## Local Policing Support Team

**RE: Former Westside Supplies Unit West of 17 to 18 Durban Road Bognor Regis PO22 9QT**

Thank you for your correspondence of the 3<sup>rd</sup> December 2021, advising me of a planning application for development of a new build four storey block of flats for 24 units (13 No 1 bed and 11 No 2 bed). This application is in CIL Zone 4 (Zero Rated) as flats at the above location, for which you seek advice from a crime prevention viewpoint.

FIRST + SECOND FLOOR PLAN

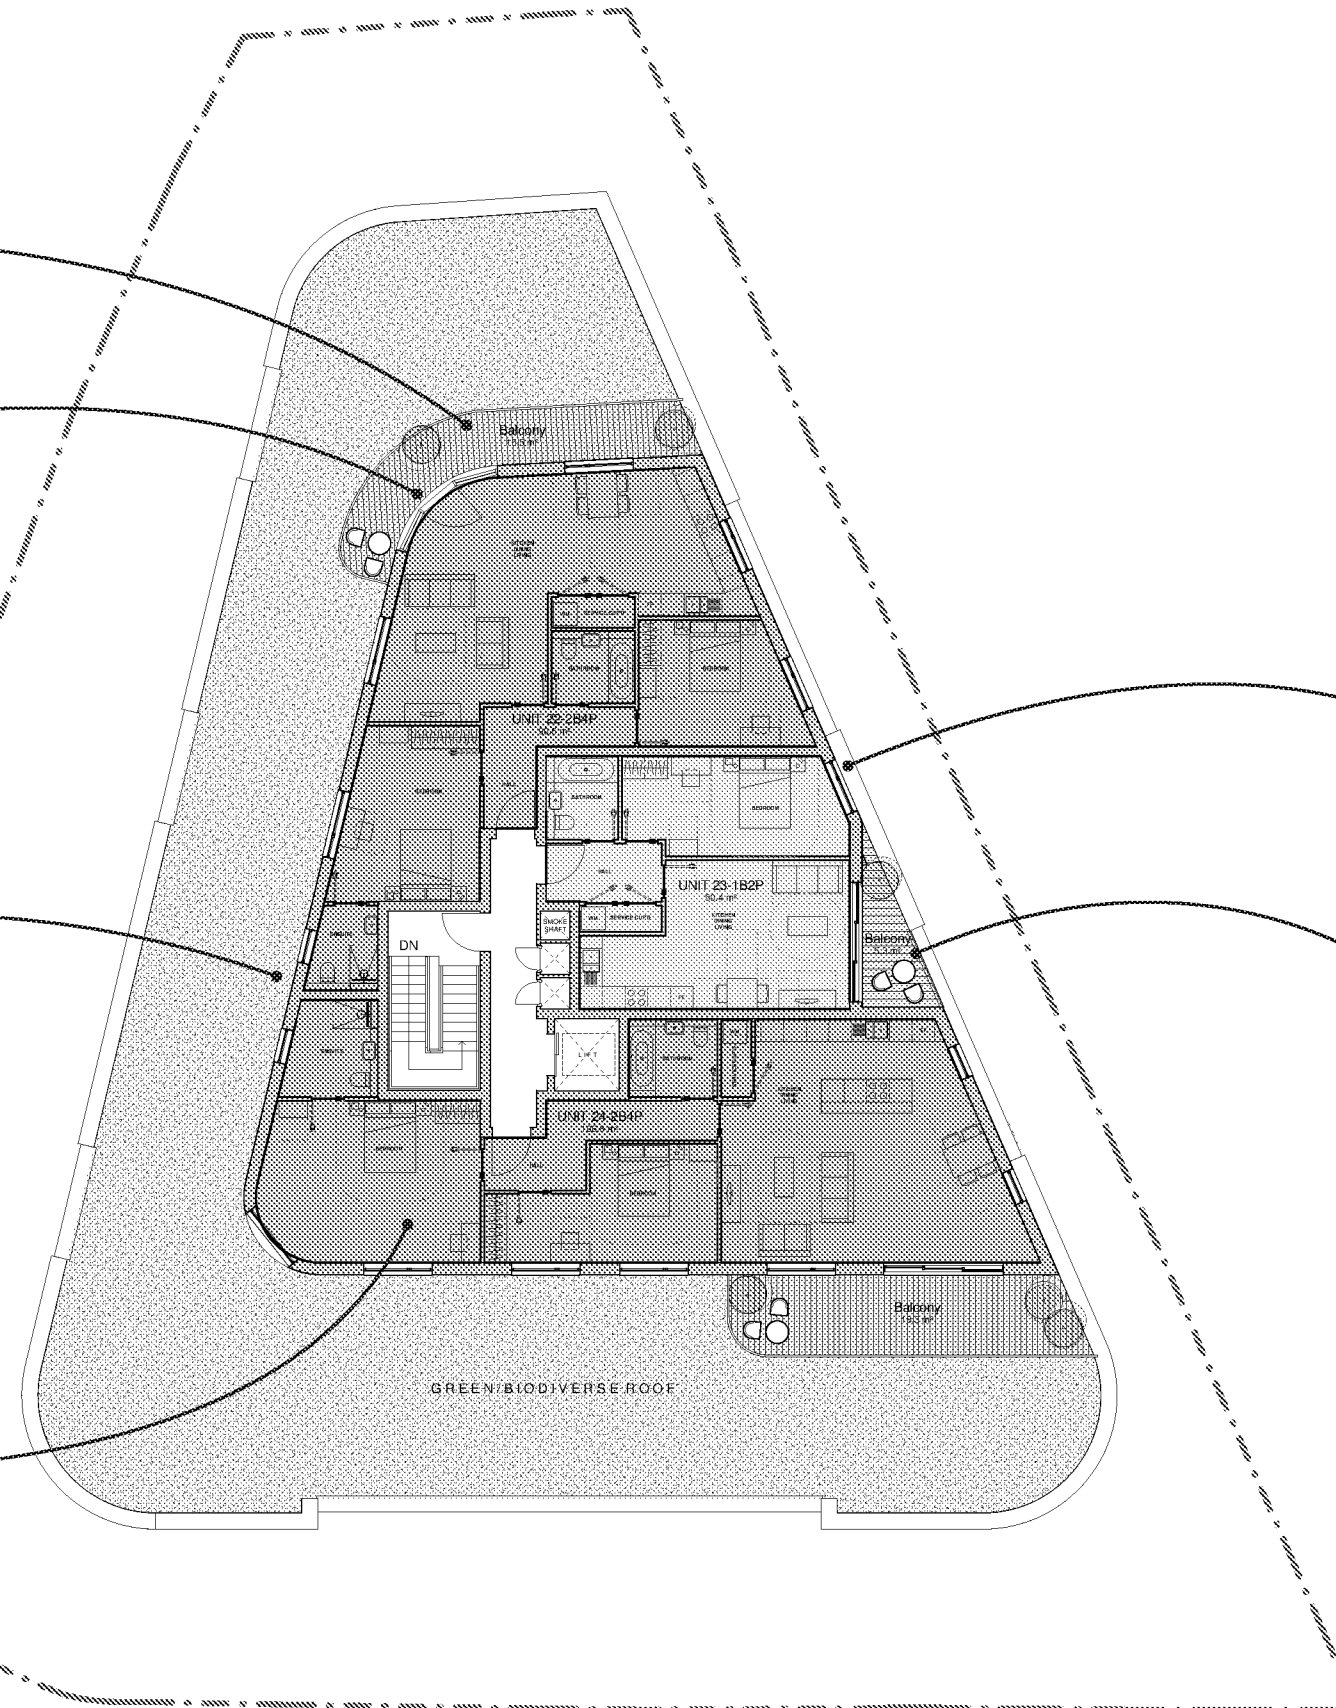
I recommend that all balconies are provided with balustrades sufficiently high to deter and prevent persons from falling or climbing over the top of them.

Surfacing and Hard Landscaping

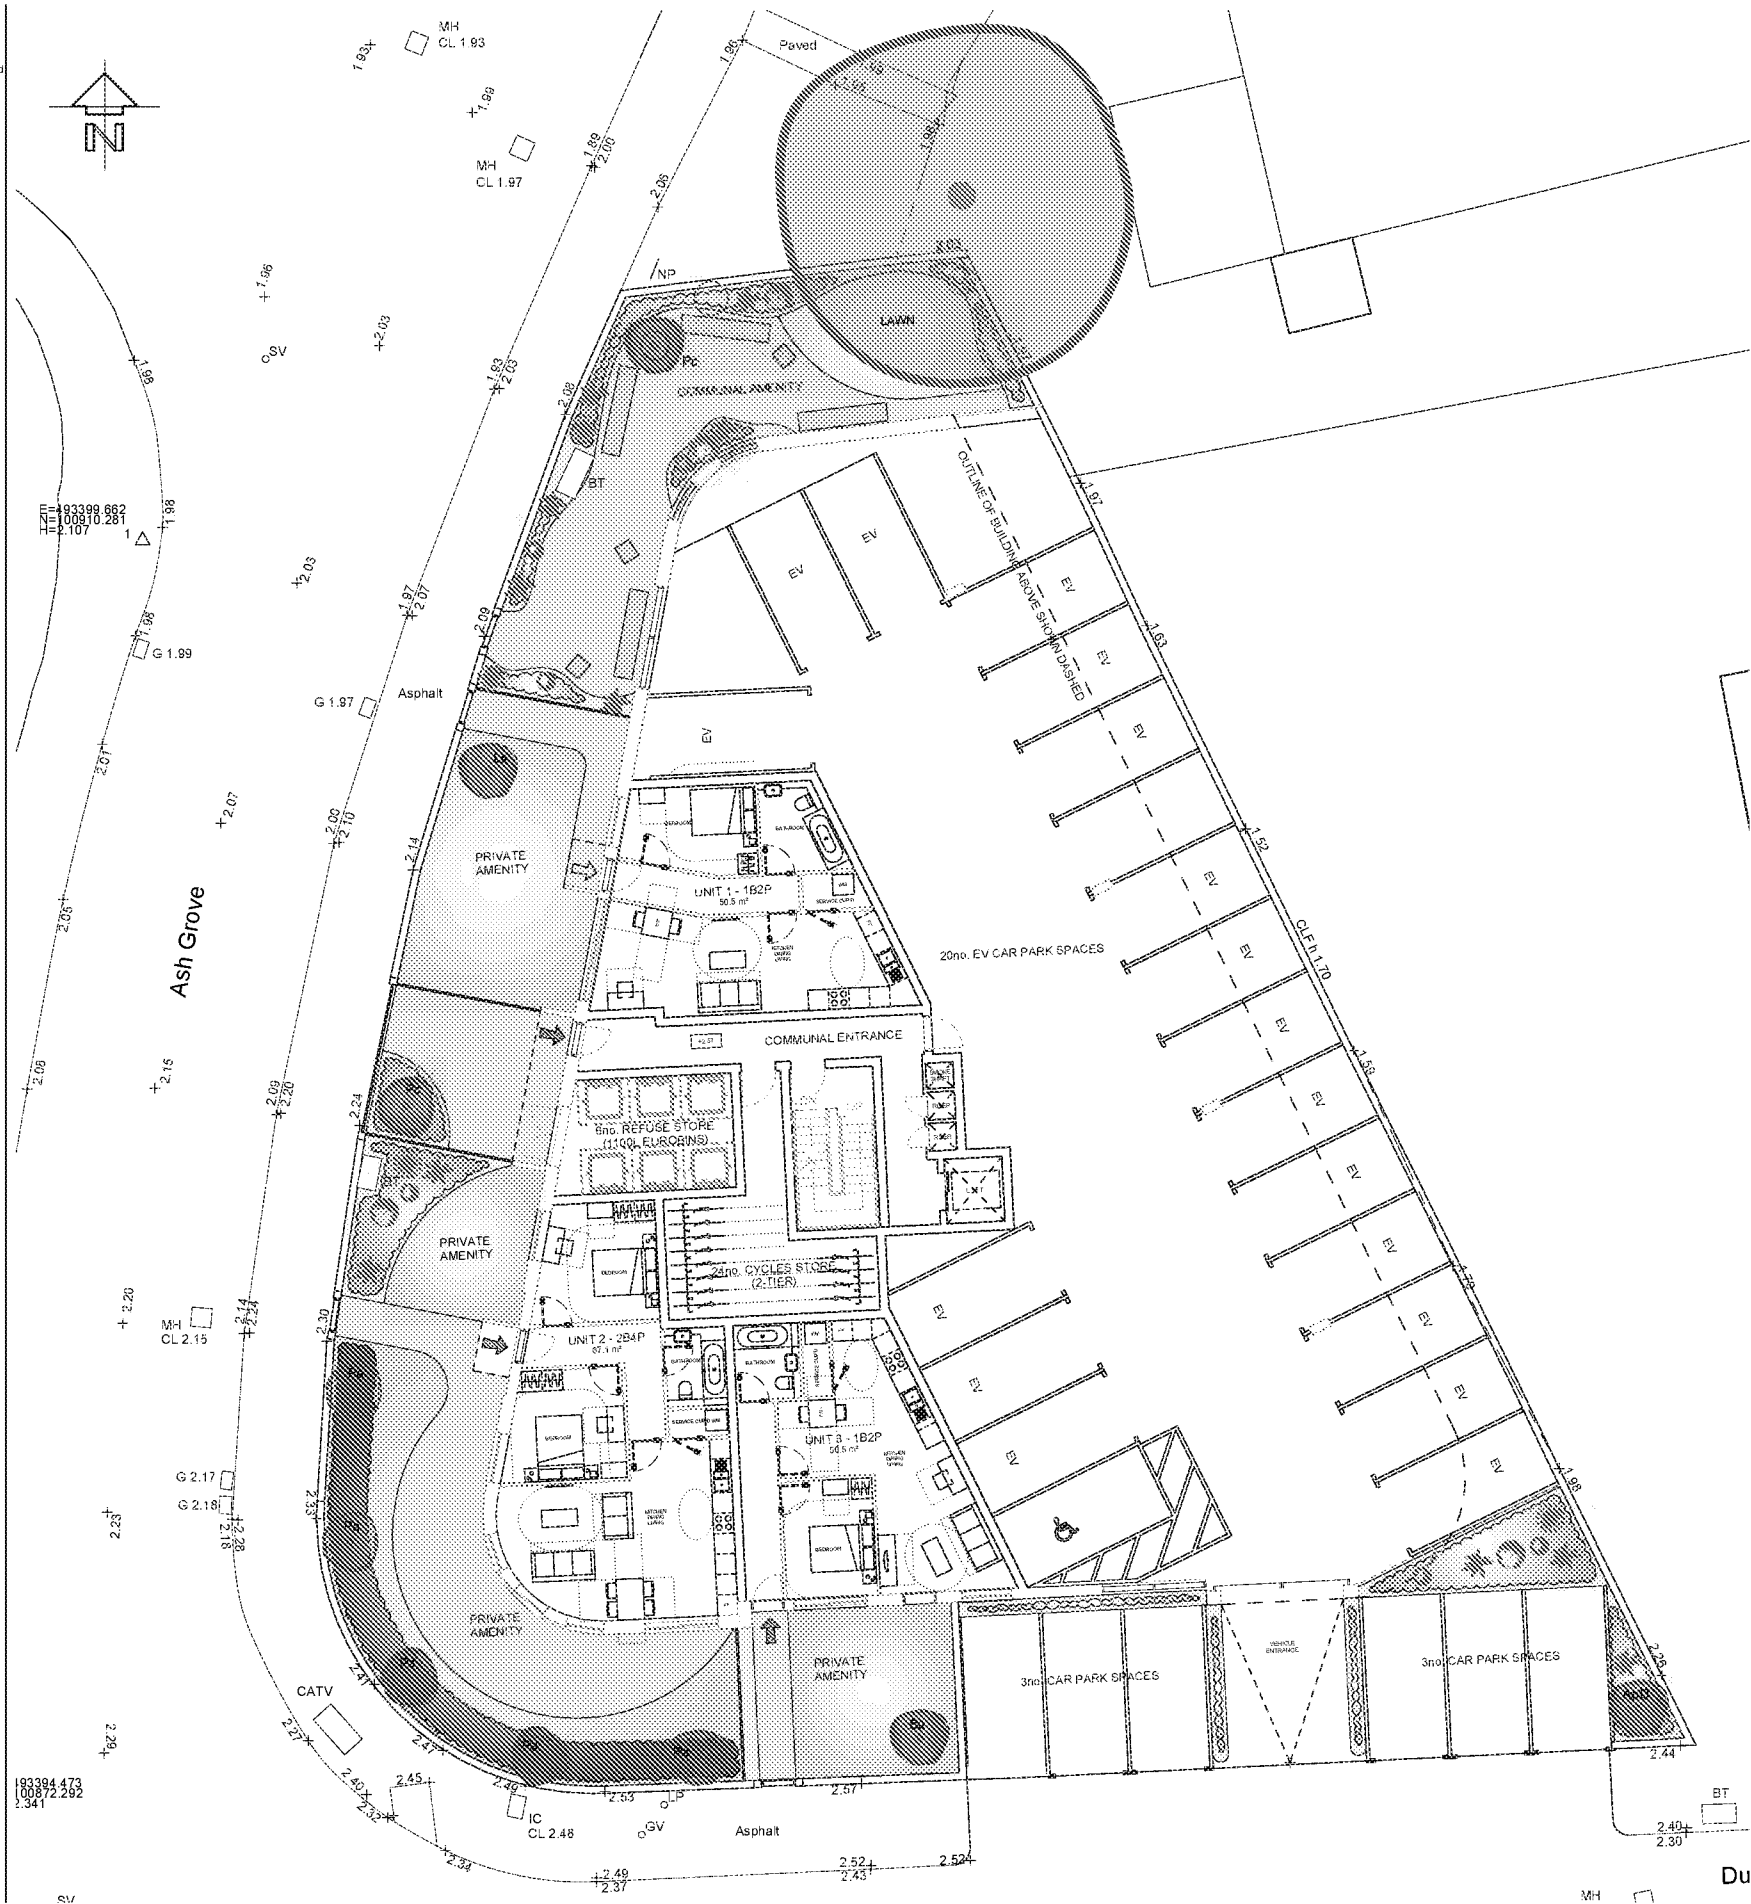
With regards to landscaping - ground planting should not be higher than 1 metre with tree canopies no lower than 2 metres. This arrangement provides a window of observation throughout the area.
